David Lowe  
Delivery Lead: Ecology, Historic Environment &  
Landscape

16<sup>th</sup> August 2023

**RE: A46 Coventry Junctions (Walsgrave Scoping) - TR010066**

Drawing Title
**FIGURE 7.1 :
LANDSCAPE POLICY CONTEXT**

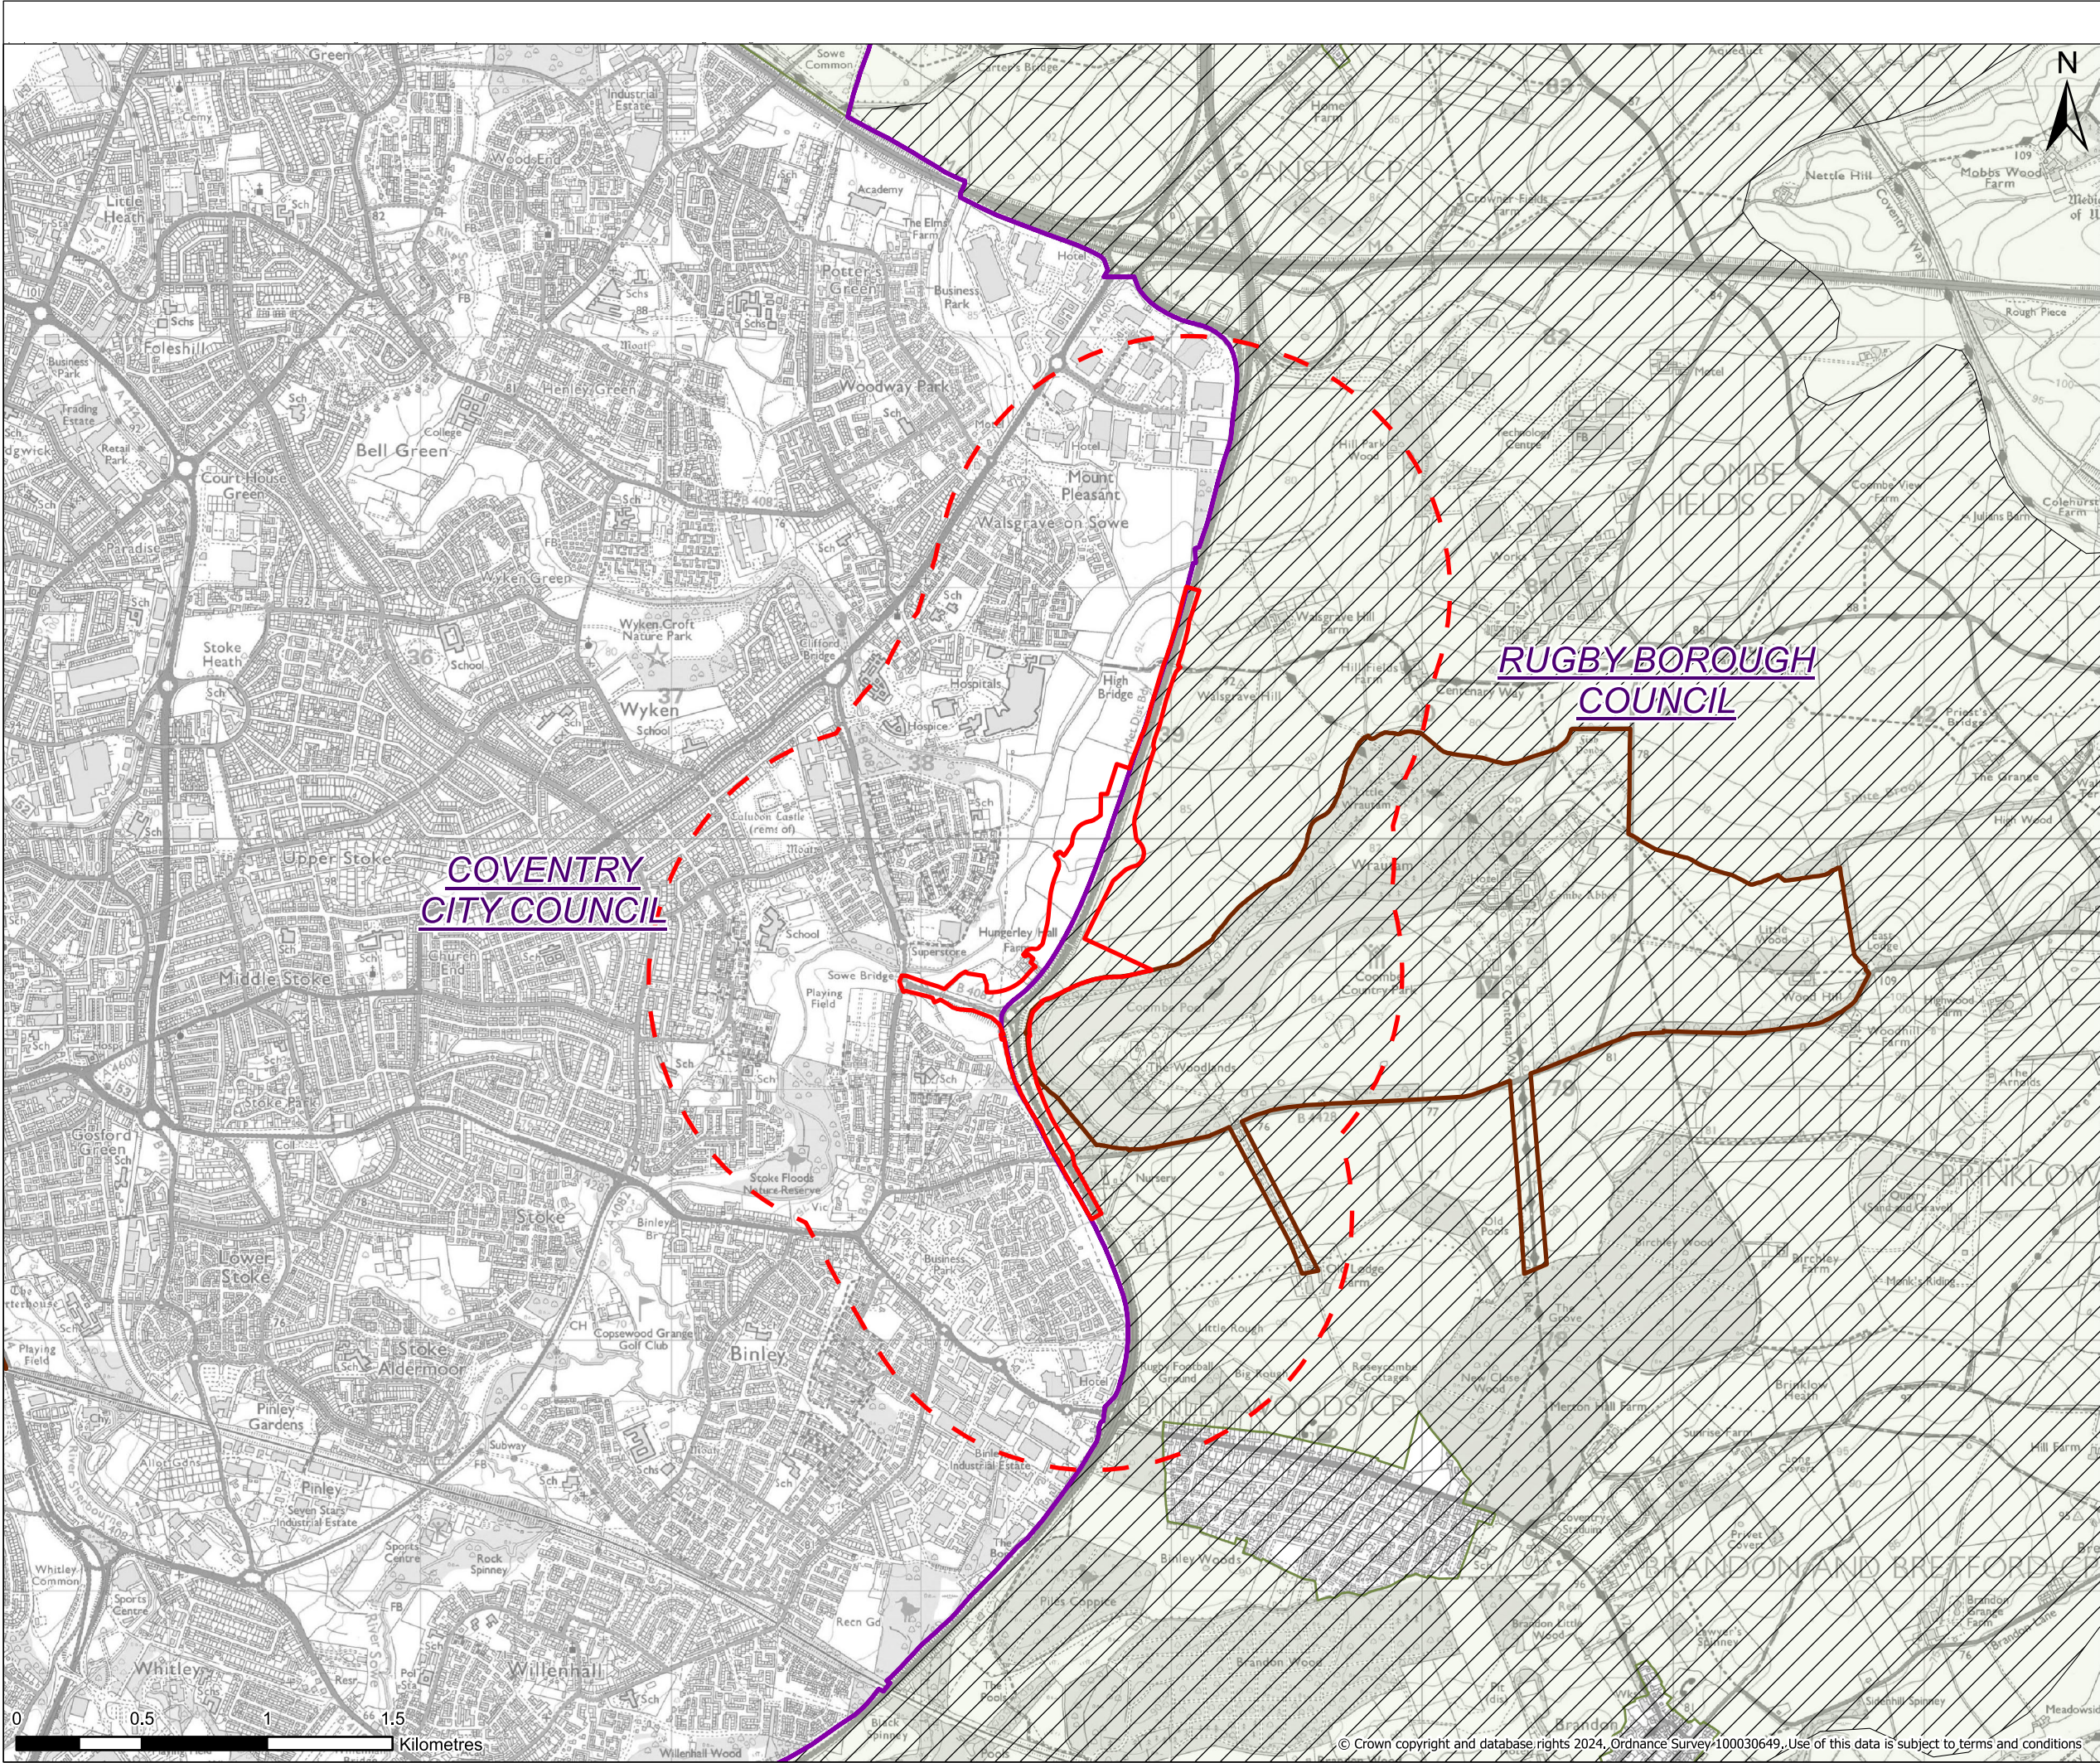
WCC would recommend that the 1km radius for the study area as referenced in Section 8.2 is extended to take into account all selected viewpoints and additional viewpoints as requested by RBC.
